From: John Brown [REDACTED]
Sent: 12 December 2017 17:11
To: David Easton
[REDACTED]
Subject: LY/9/17/PL - Roseland, The Causeway, Arundel, West Sussex BN18 9JL

In response to Kevin Browns (Highways England Companies Limited) e-mail to you dated 14th August, 2017, Highway England reference 78585
I would respond to the points raised there in as follows –

Proposed illustration of site approach travelling North on The Causeway Road:

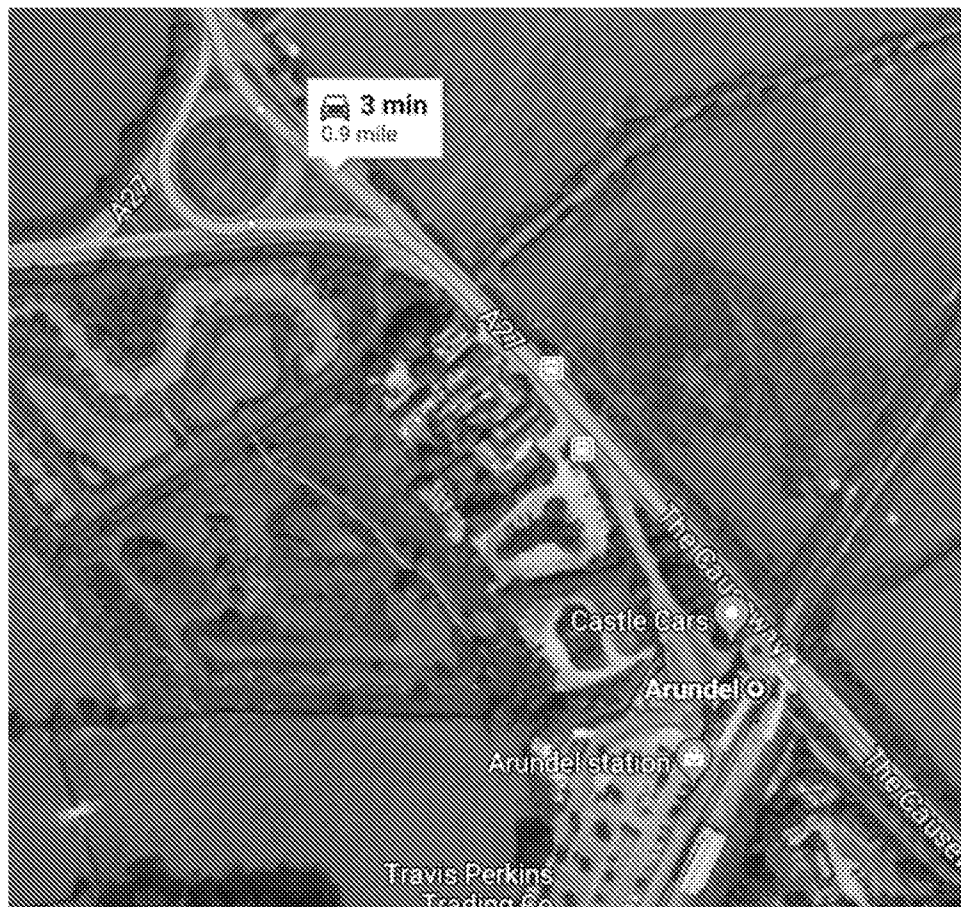
Construction management plan, item 2.3 updated to show the HGVs continuing to the A27 / The Causeway roundabout to make a U-turn before travelling south and entering the site from the RIGHT.
